Ribble Valley Borough Council
By email

Your ref 3/2026/0315
Our ref DC/26/1724
Date 31-JUL-26

Location: Land off Chatburn Road Clitheroe BB7 4JX

Proposal: Residential development of 39 dwellings with associated landscaping, car parking and access

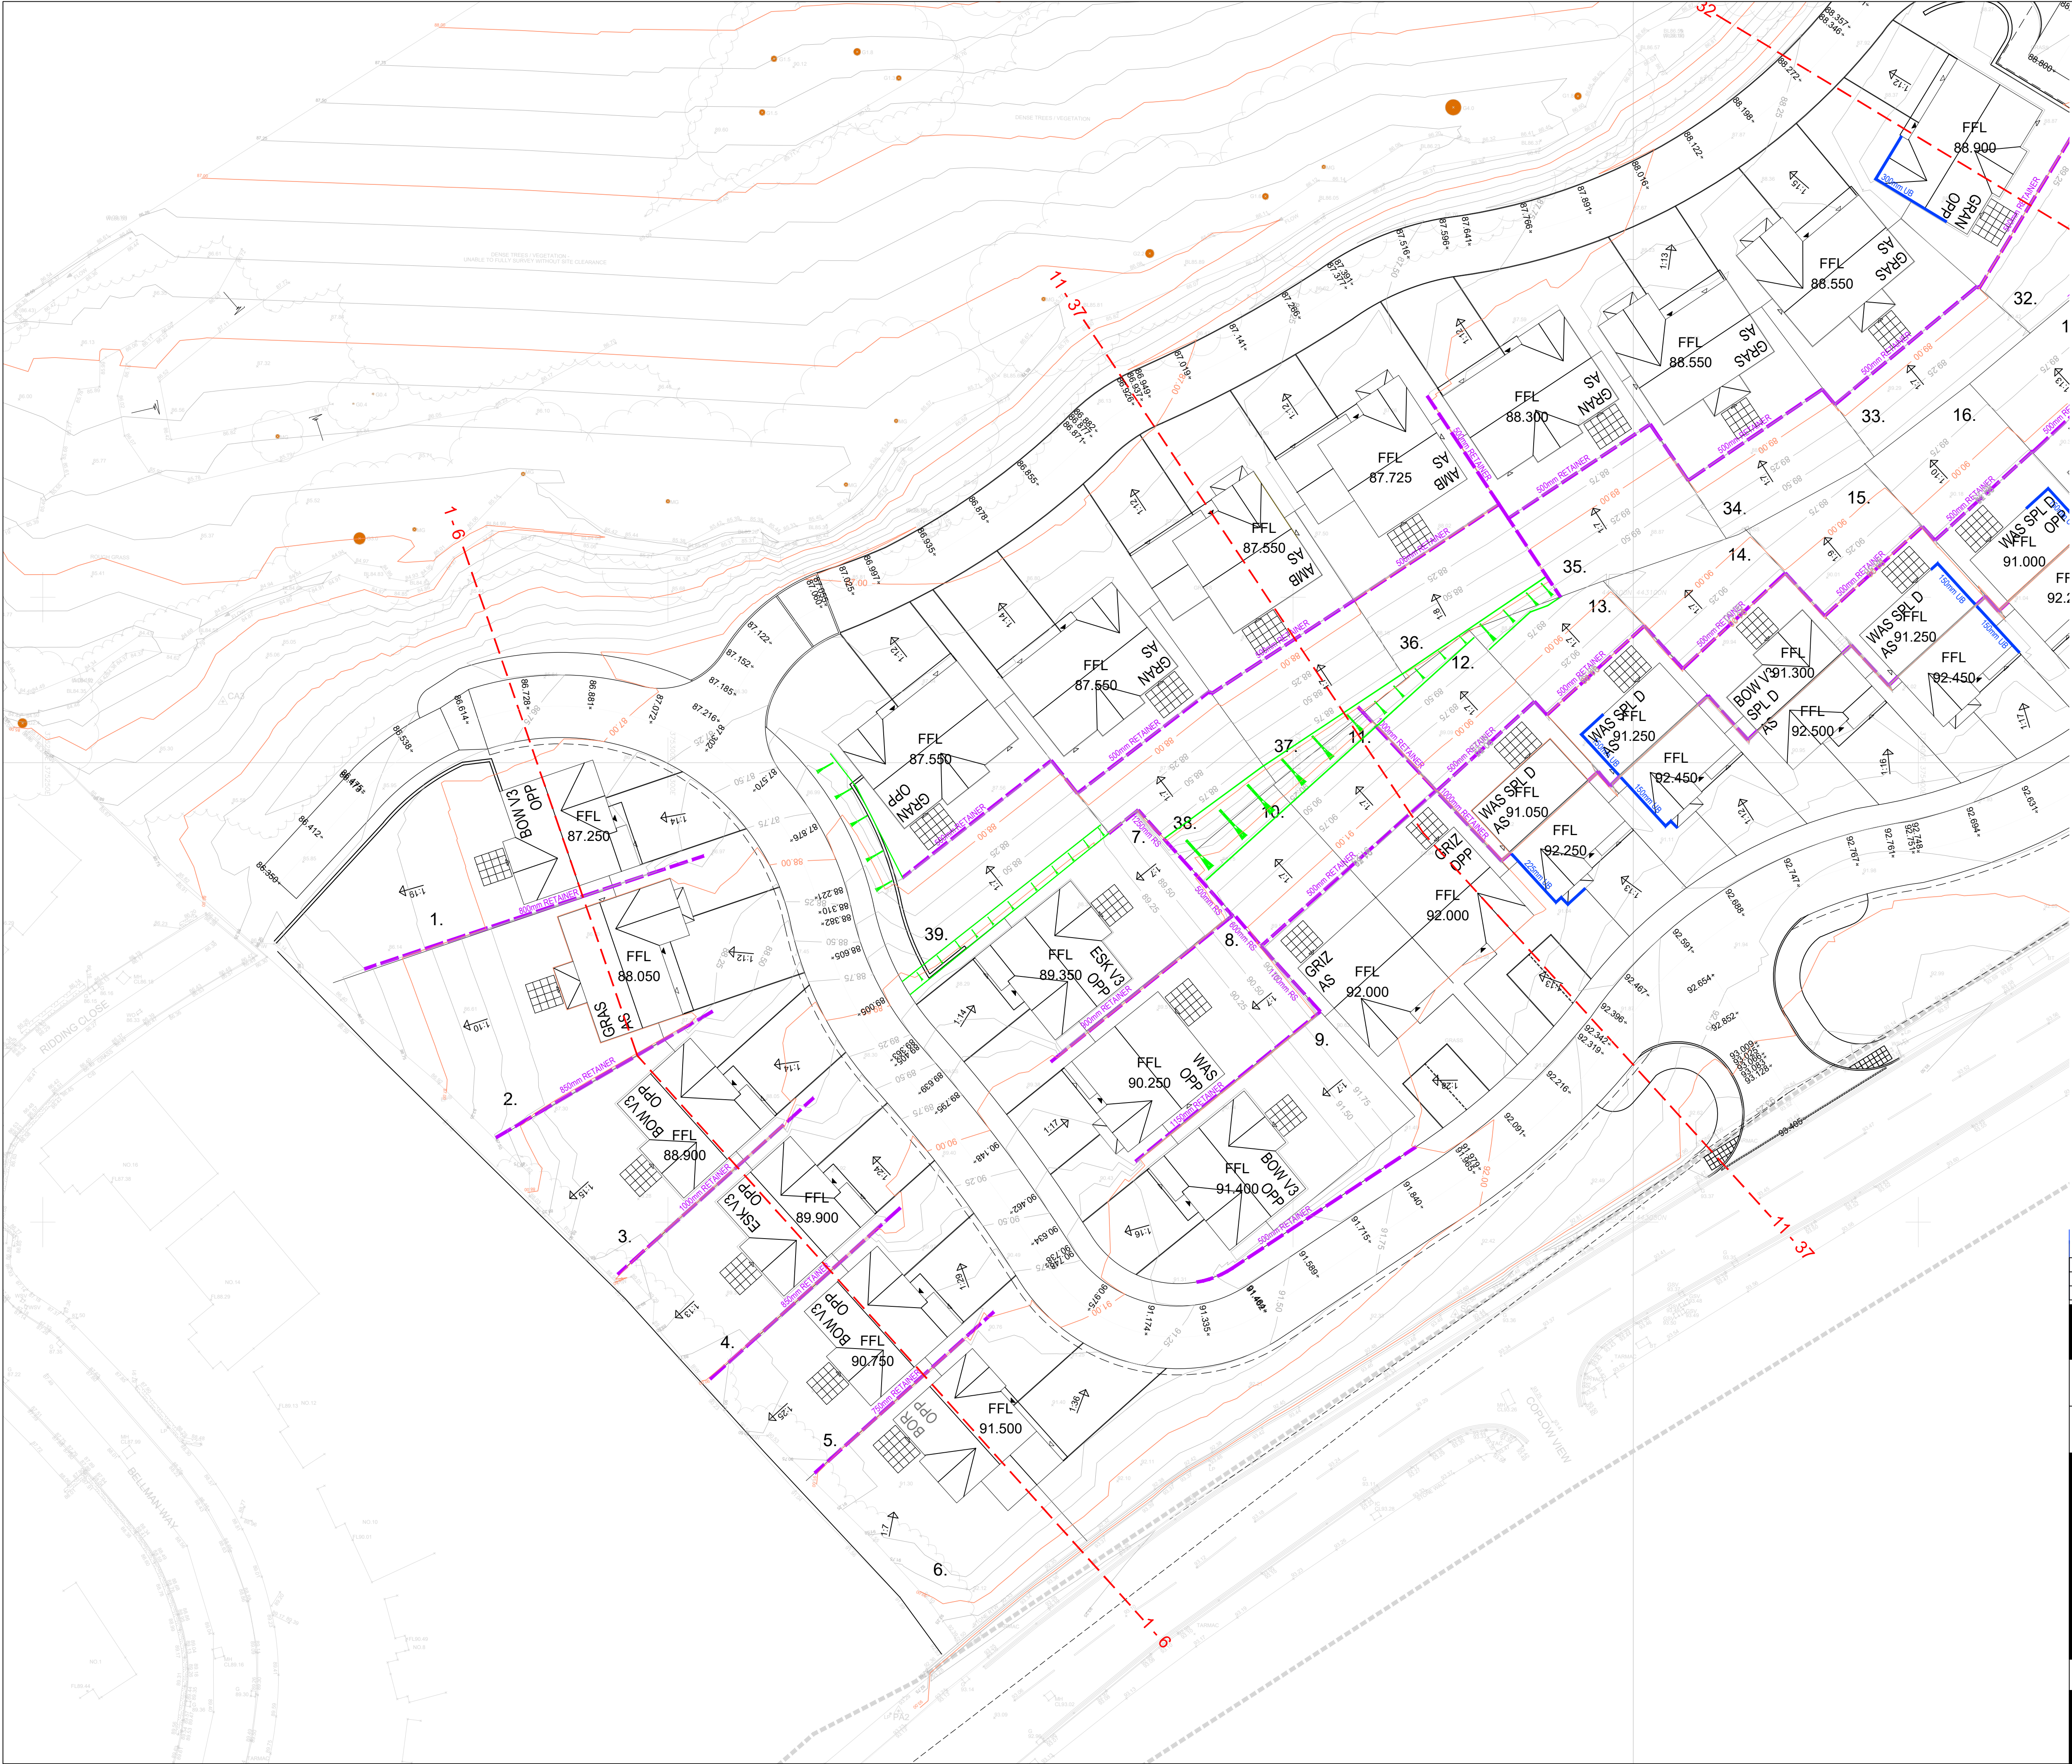
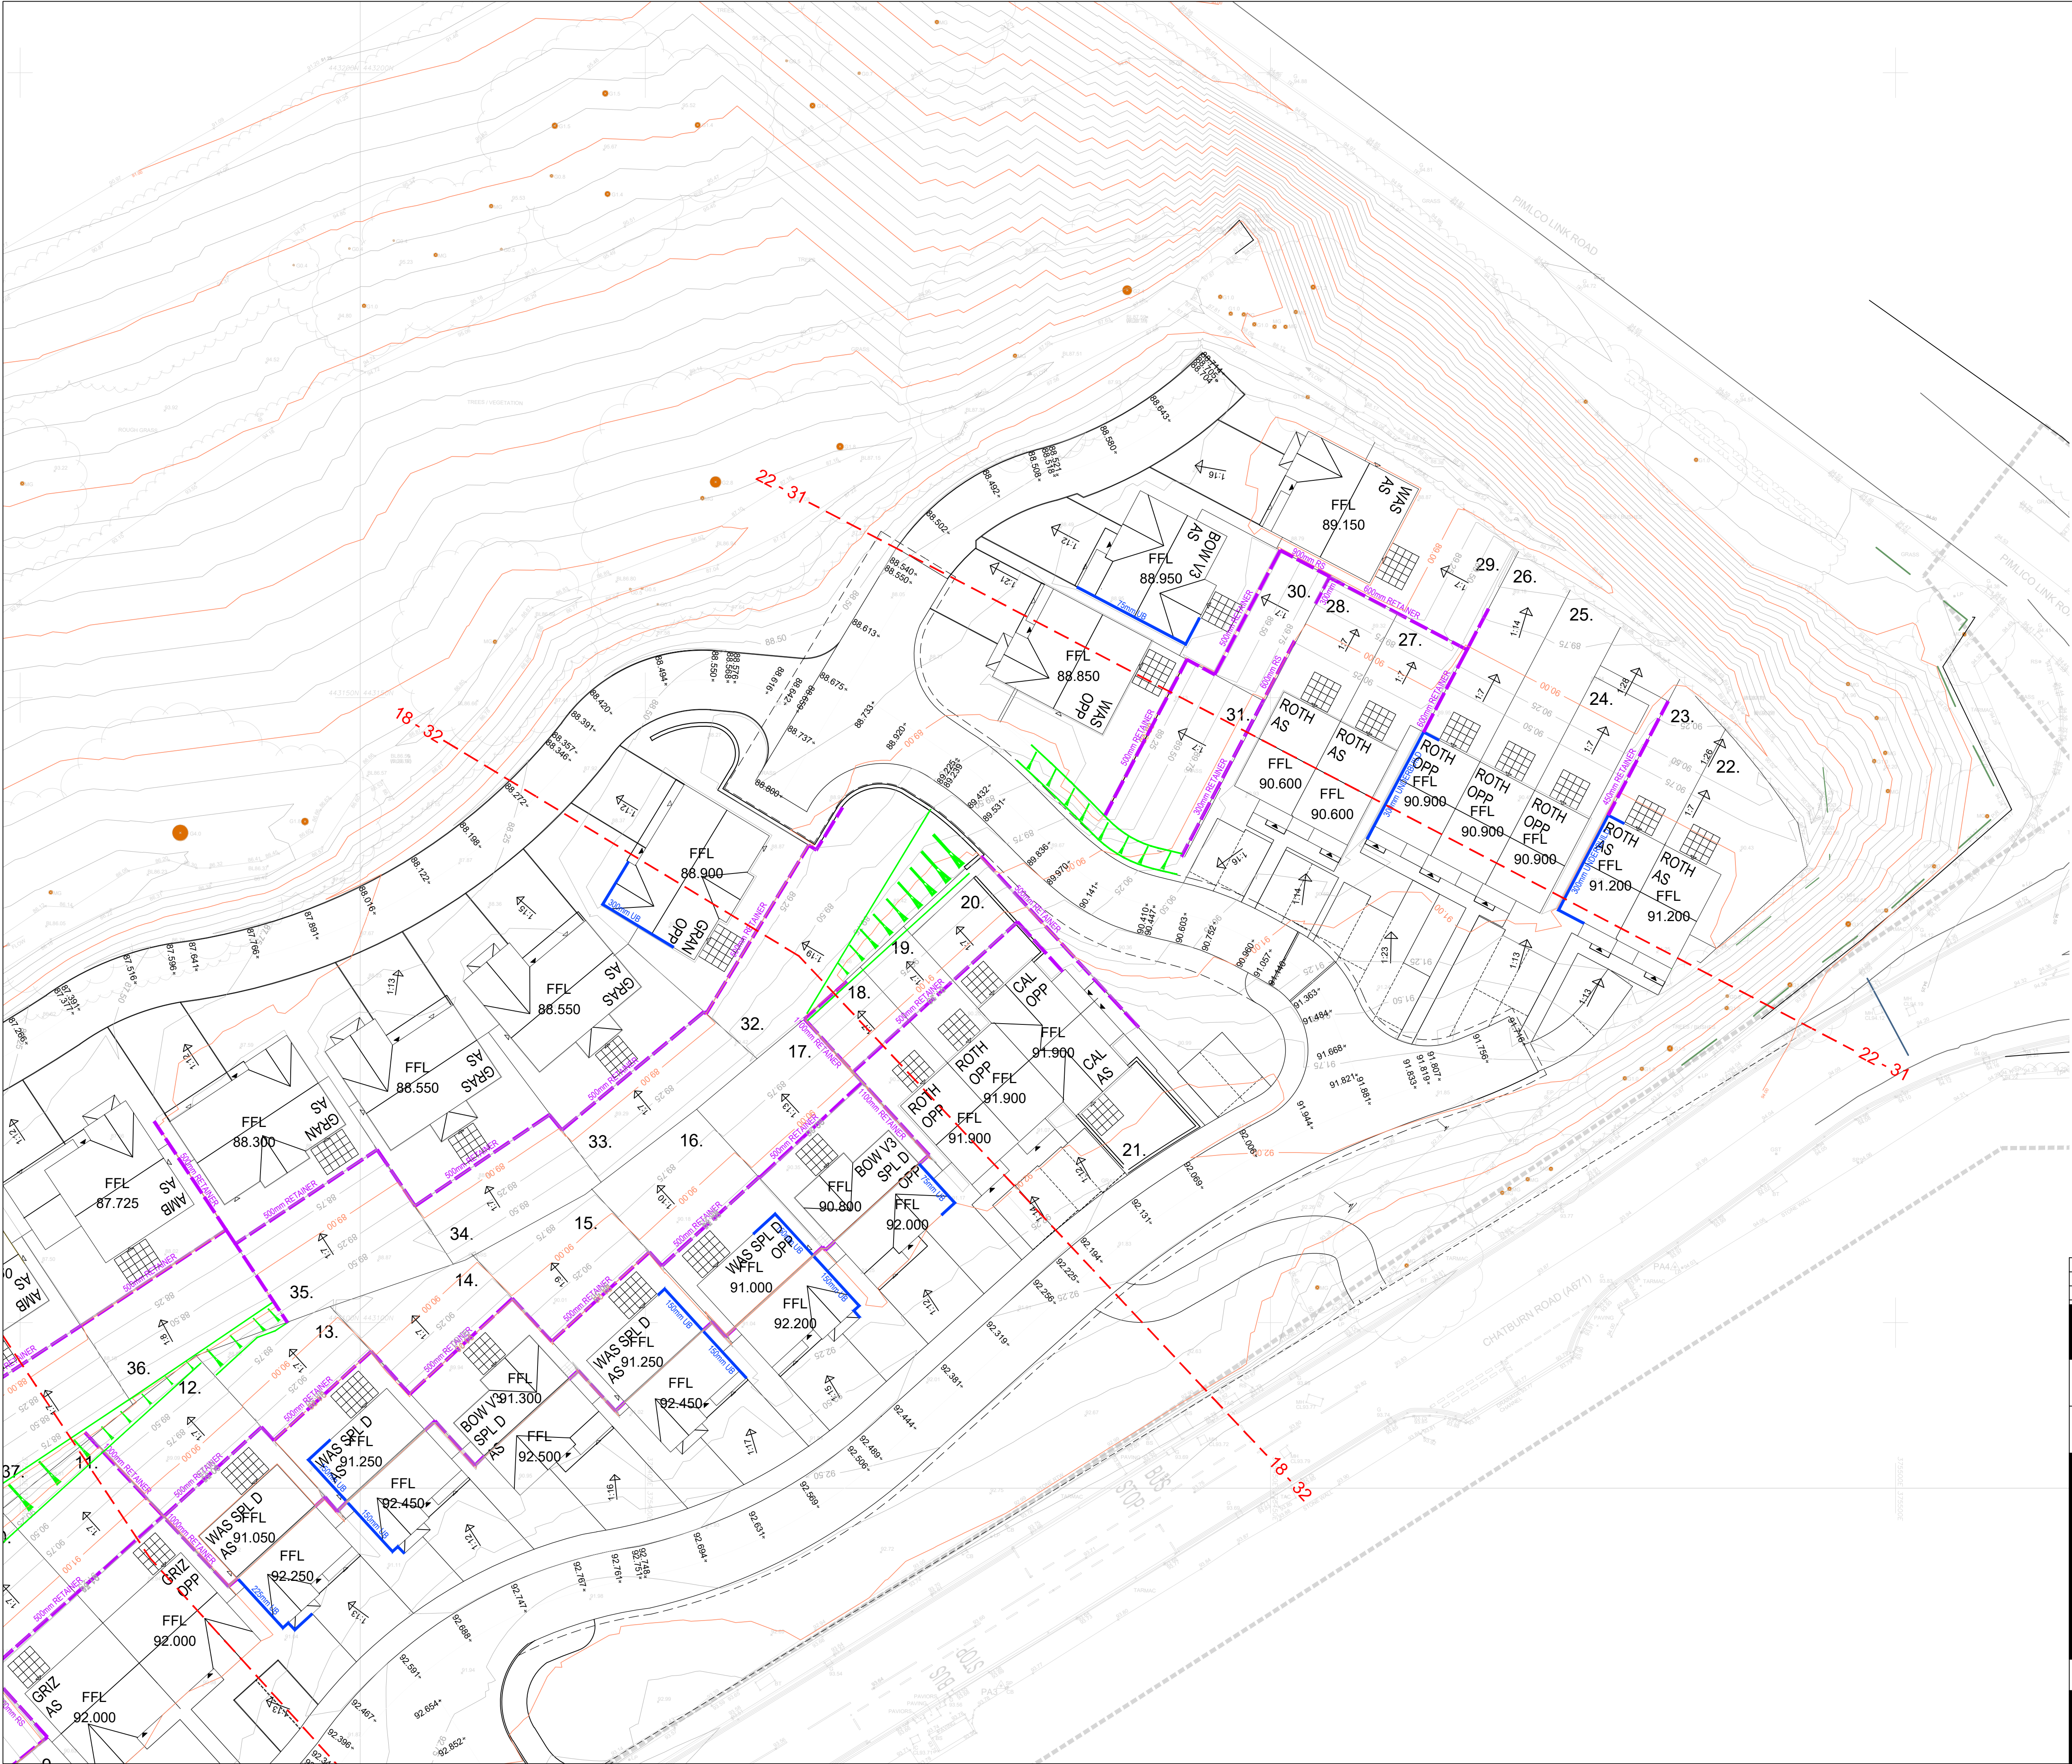
Following our review of the submitted Drainage Strategy, prepared by Gadsden Consulting, Ref: 26117 and Drainage drawings: 26117-GAD-00-00-DR-C-1001-P02, Dated 23.04.2026 & 26117-GAD-00-00-DR-C-1002-P02, Dated 23.04.2026, we can confirm that whilst the strategy for the disposal of foul and surface water is acceptable in principle, there are elements of the detailed drainage design that might not be acceptable to United Utilities and will require resolution by the applicant.

In particular this relates to foul connection point to the known network has not been shown and drainage cover levels are above or within 150mm of adjacent property FFL's.

Prior to the commencement of development, details of a sustainable surface water drainage scheme and a foul water drainage scheme shall be submitted to and approved in writing by the Local Planning Authority. The drainage schemes must include:

(iii) Levels of the proposed drainage systems including proposed ground and finished floor levels in AOD;

(v) Details of points of discharge for foul and surface water;
